EXPERT APPRAISAL

RETENTION OF SINGLE STOREY EQUESTRIAN STORAGE

Warren Wood
Manor,
Hornbeam Lane,
Essendon, Herts.

December 2016

Appendix 3 – First floor plan of stable block

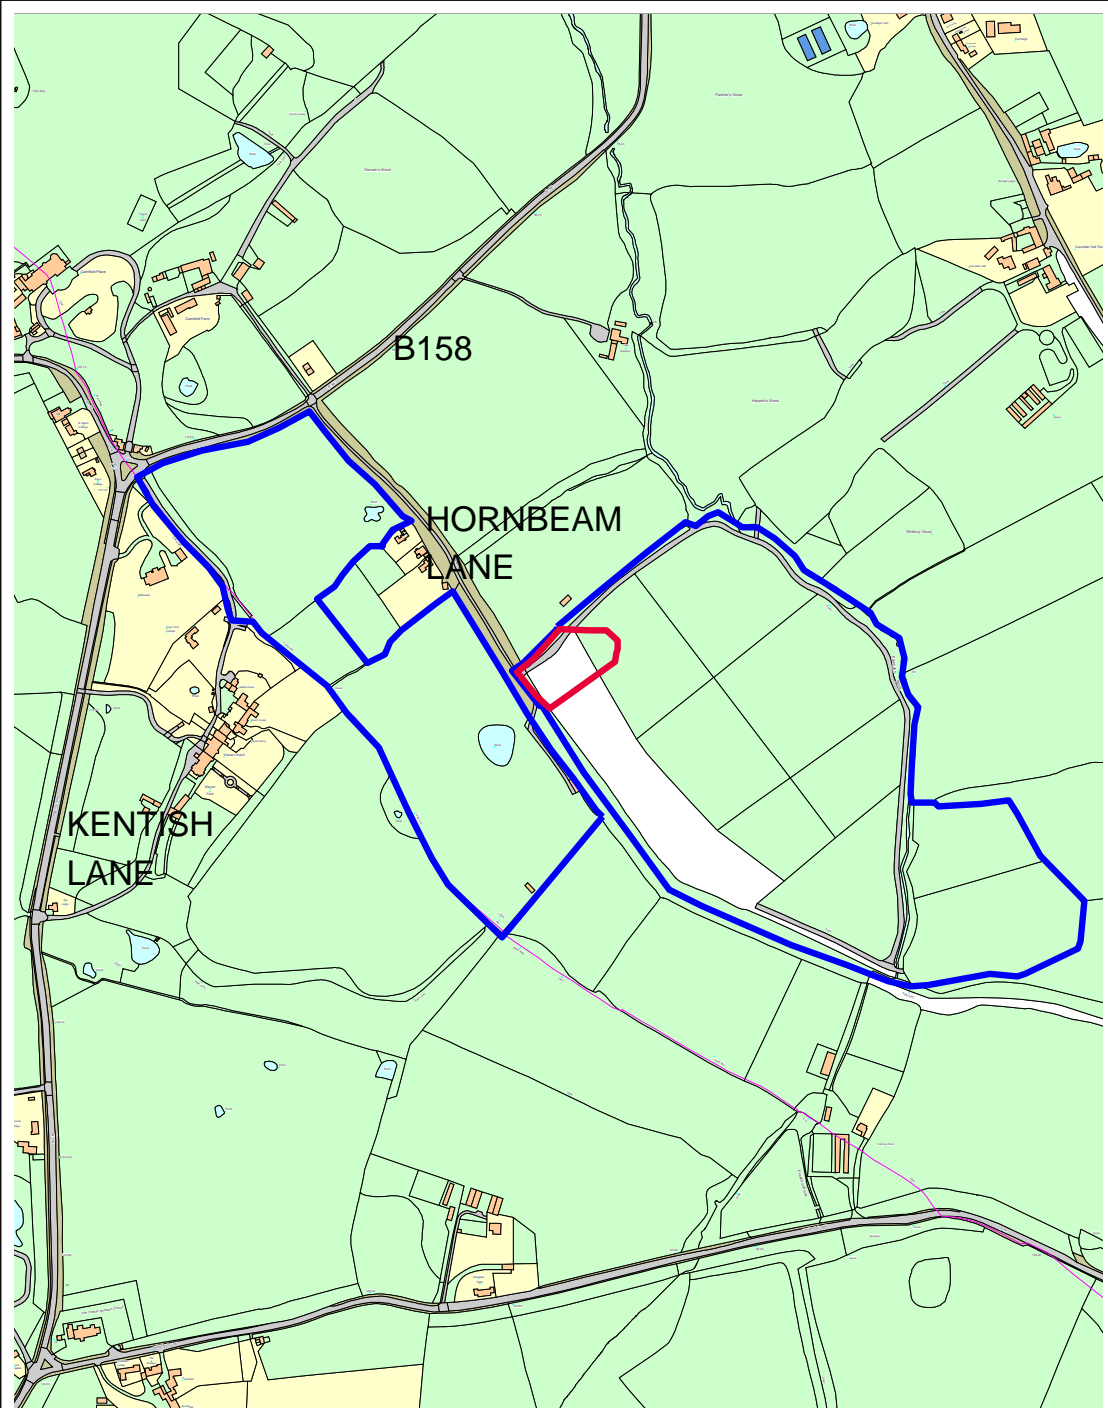
- 6.13. On reviewing the approved plan 541-06 which provides the internal layout to the ground floor of the Stable Block and As Built drawing 703/100 showing the first floor internal layout, it is clear that the Stable Block has been designed and built with significant storage. There are two very large Hay Stores set out on the first floor with a further Feed and Hay store provided on the ground floor which benefits from its own dedicated access via a set of double doors.

- 6.14. The Supporting Statement and appendices A and B claim that the approved large Hay Stores on the first floor of the Stable Block cannot be accessed as there are no appropriate openings and a mechanical load lifter is required to manoeuvre these. This claim is accepted although it is extremely surprising that anyone with any knowledge of equestrian operations would design, apply for planning permission or build a Stable Block with essential hay storage on the first floor without any appropriate access. It also means that large areas of the first floor of the building have no functional use.

- 6.18. The JSP report also refers to the lack of airflow preventing the original storage areas from being utilised. It is accepted that airflow is important to appropriate storage management and that this may well have been an issue for the first floor hay storage areas, but this would not prevent these areas of the building being used for alternative

GROUND FLOOR LAYOUT

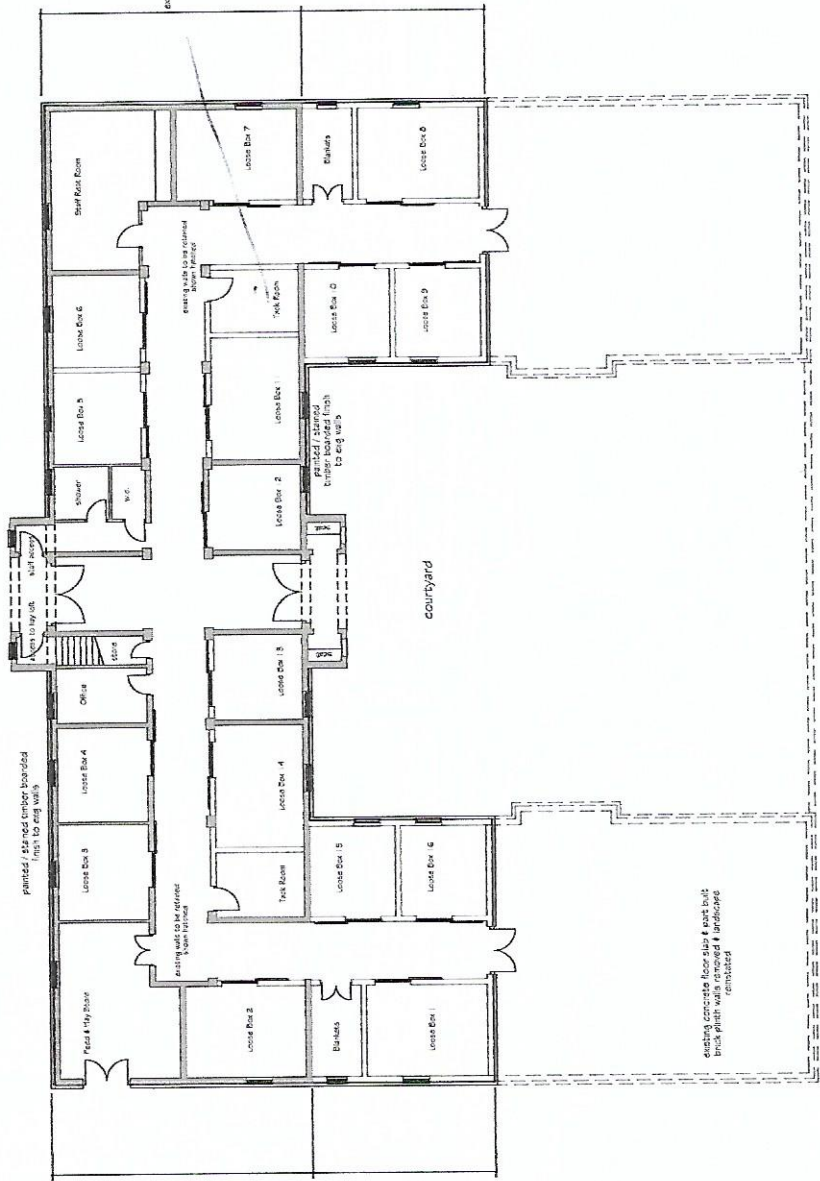
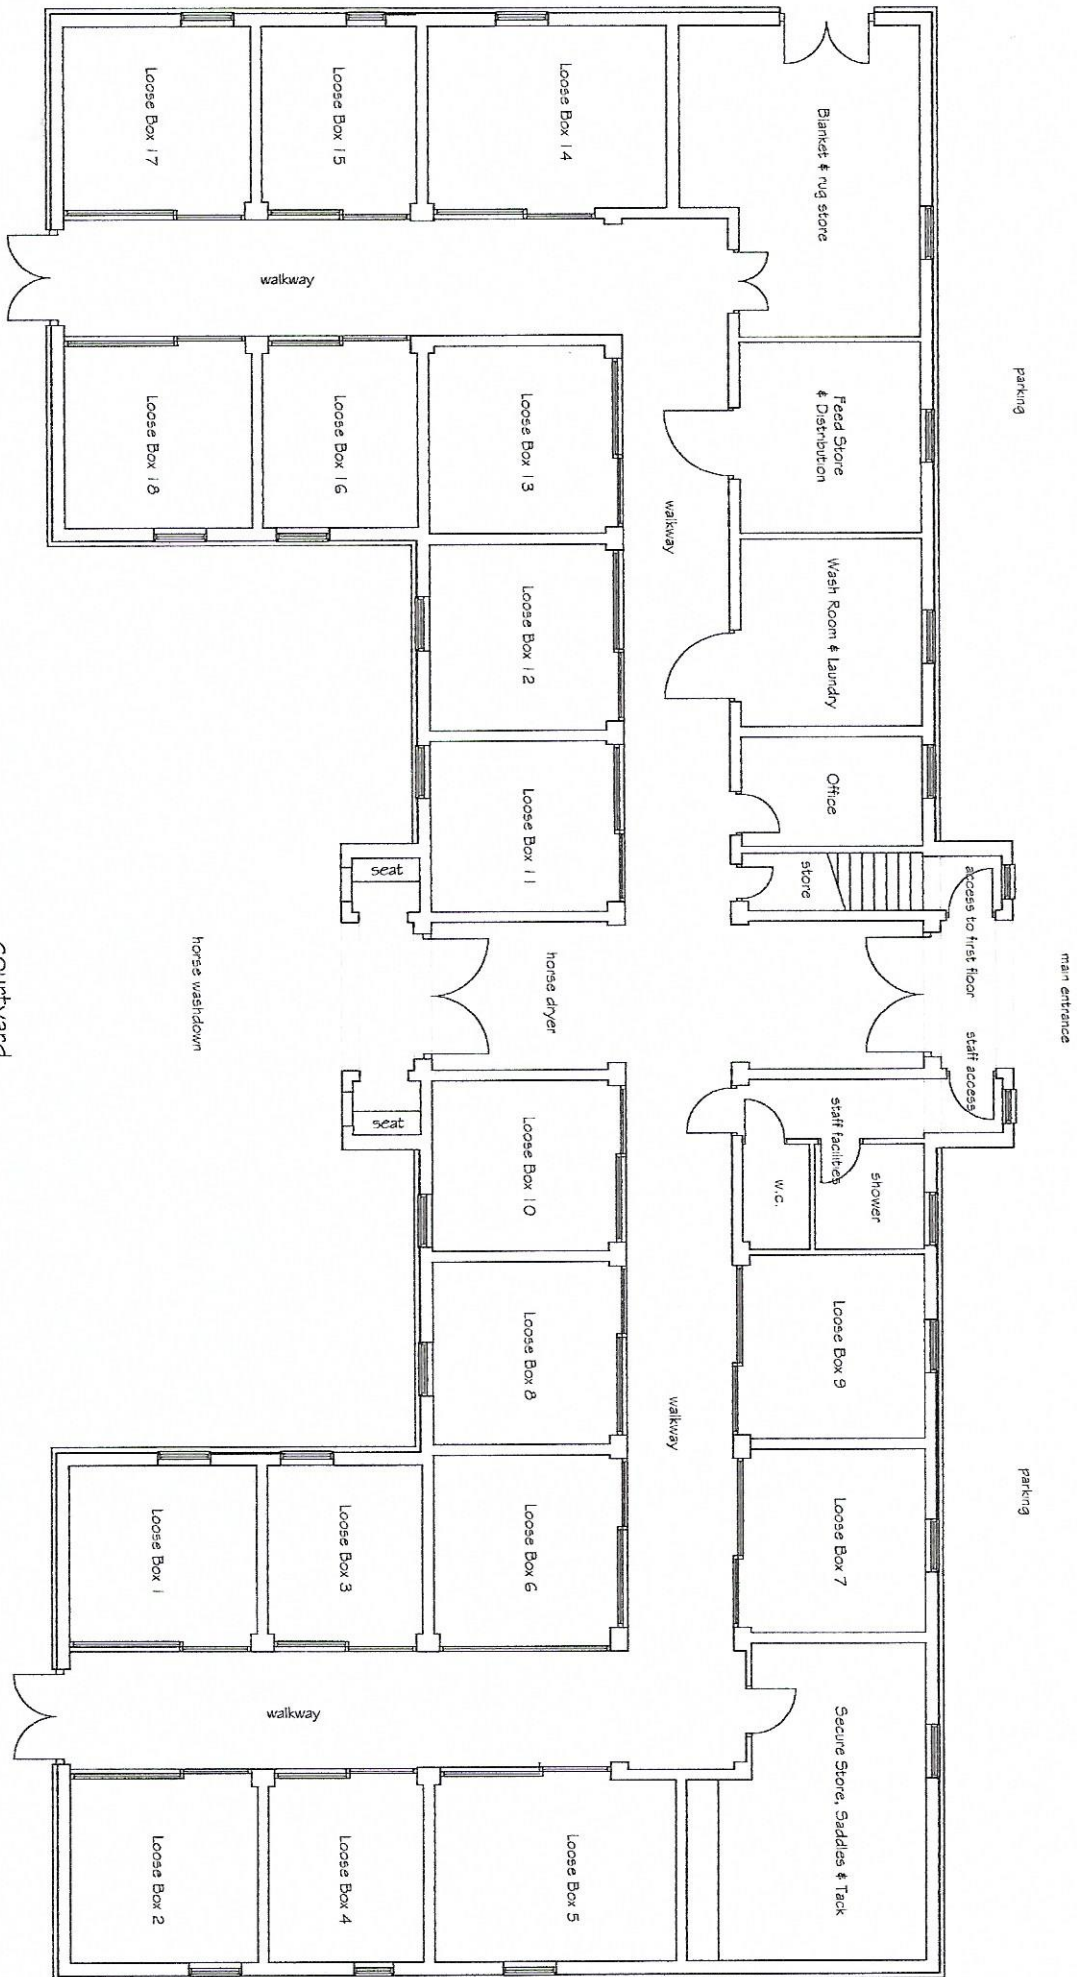
- 6.16. Paragraph 4.3 of the JSP report states that 4m x 4.8m of floor space is required to provide the storage space for the required hay. The ground floor Feed and Hay Store shown on approved plan 541-06 provides more space than this and could therefore reasonably accommodate the 16 bales of hay required for functional purposes. The double doors mean it could also be accessed with appropriate manoeuvring machinery.

- i. In Appendices A The Stable Manager sets out the uses of individual rooms within the stable block. This does not seem to correspond with approved plan 541-06. However, it is noted that rooms referred to are tack room, an office and a rug room all of which could feasibly be relocated to the first floor where the Hay Storage areas are not in use, to provide more storage space on the ground floor.

6.19. A review of drawings 541-06 suggests that simple internal remodelling of the building could provide more than sufficient space internally for the required storage. One such option is set out below:

- Convert the south eastern wing (comprising the Feed and Hay Store, Loose Box 1, 2, 15 and 16 as well as the Blankets store and associated access) to an internal storage area providing an additional storage area that is very similar in size to the separate Storage Barn and which could be partitioned off from the rest of the building to reduce fire risk and the creation of dust. This would benefit from two access points which would be accessible by machinery for both manoeuvring purposes and machinery storage purposes.

- This would result in the loss of four stables which would need to be provided elsewhere within the Stable Block:
 - Loose Box 14 and the adjacent Tack room could be remodelled to provide two reasonable size stables. As could Loose Box 11 and its adjacent Tack Room and Loose Box 4 and the Office. This would provide three additional stables. The Tack Rooms and Office could reasonably be relocated to the first floor in the disused Hay Storage areas.

- The Stall Reps Room could be converted to a stable and the functional use relocated to the first floor as per the Tack Rooms or similarly Loose Box 7 or 8 and the Blanket Store could be remodelled in the same way. This would provide the fourth stable lost as a result of the new storage area.
